Proposed Residential
Development at Howth Road,
Dublin 3

Stage 1 Road Safety Audit

Document Ref: P21-018-RSA-PD-RP-001

DRAWING No. HOW-BMD-00-ZZ-DR-C1002	ISSUE P5
--	--------------------

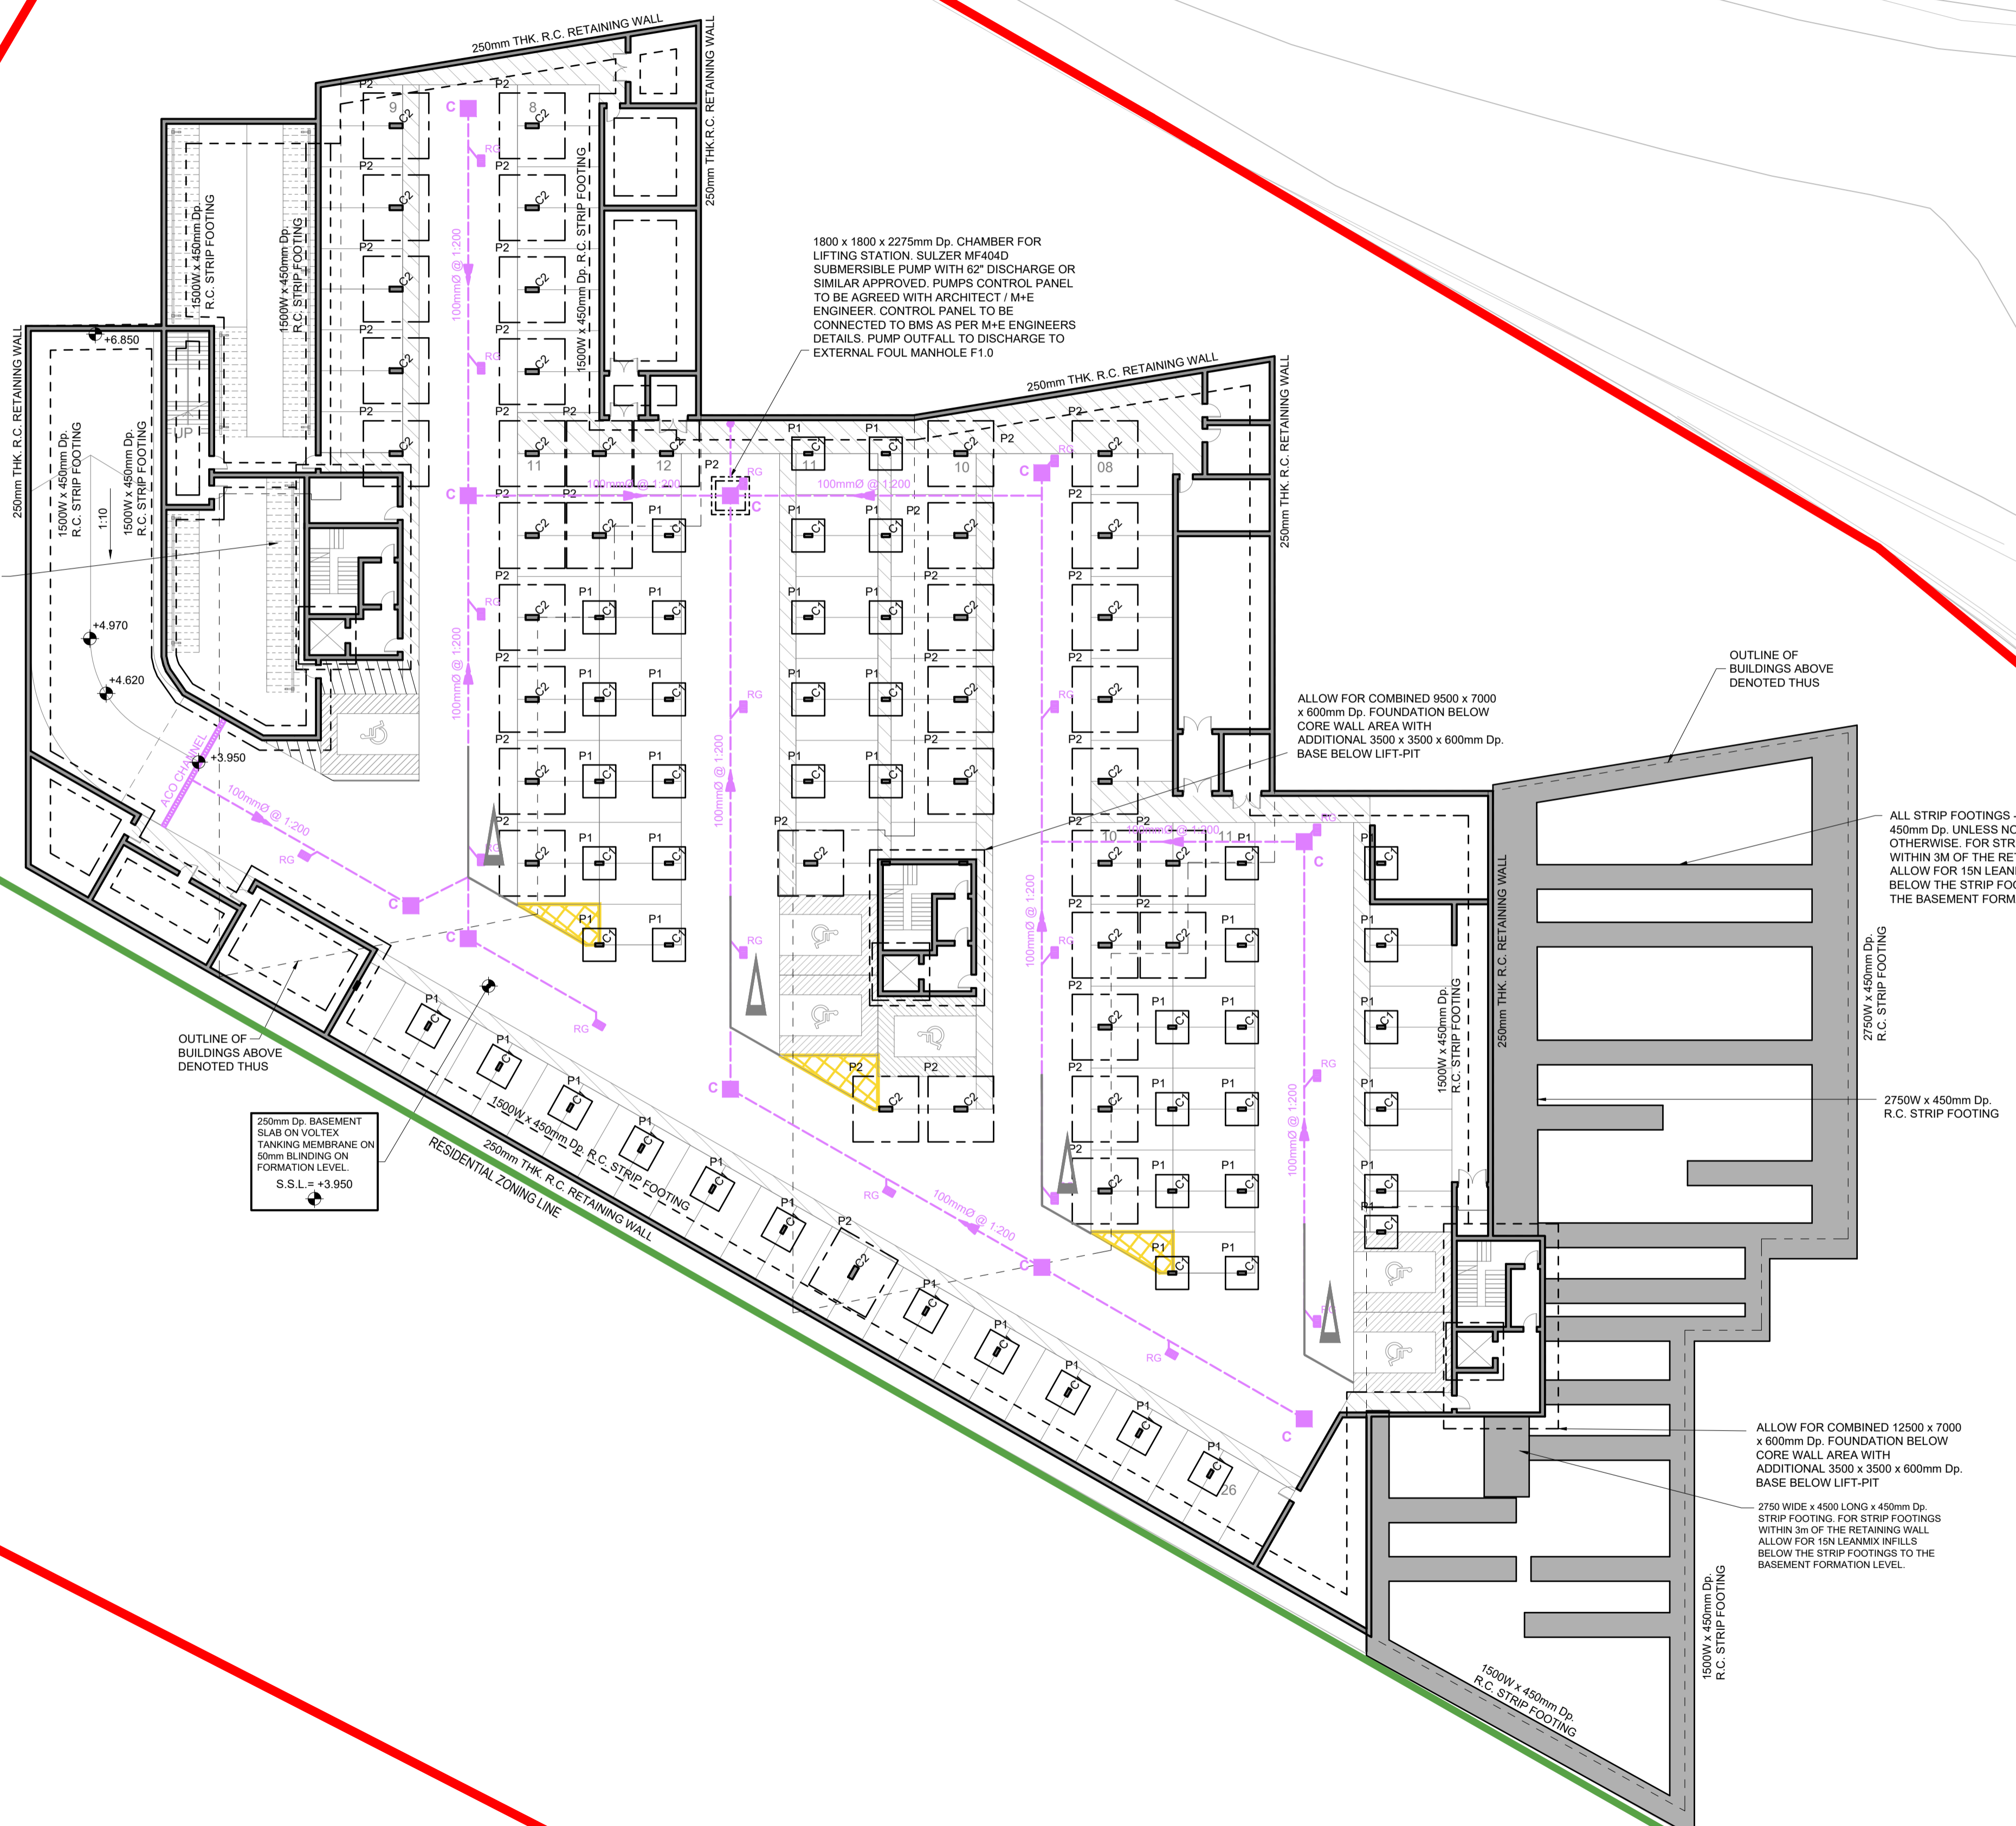
Location: Drawing HOW-BMD-00-ZZ-DR-C1002 (Rev. P4)

Summary: Drivers may park in areas not designated for parking resulting in them encroaching into the traffic lanes.

Triangular areas have been indicated at the end of parking aisles within the basement carpark. The Audit Team is concerned that, should all the spaces in the carpark be occupied, drivers may park their vehicles at these locations where there is insufficient space for a vehicle to park safely outside the carpark carriageway. Should drivers park in these locations, there is a risk of vehicles encroaching into the traffic lane resulting in an increased risk of low speed material damage collisions.

Location: Drawing HOW-BMD-00-ZZ-DR-C1002 (Rev. P4)

Summary: Junction control and priority has not been indicated within the basement carpark.

Junction control and priority has not been indicated at locations where the aisles within the carpark intersect. This could result in driver confusion and hesitation leading to collisions should drivers assume that they have priority over vehicles in adjacent carpark aisles, leading to low speed collisions and material damage.

If these areas are for smaller vehicles (i.e. motorcycles), ensure they are sufficiently marked as such. Otherwise, these areas should be hatched

Junction control and priority should be clearly provided via roadmarkings at locations where aisles intersect within the carpark.
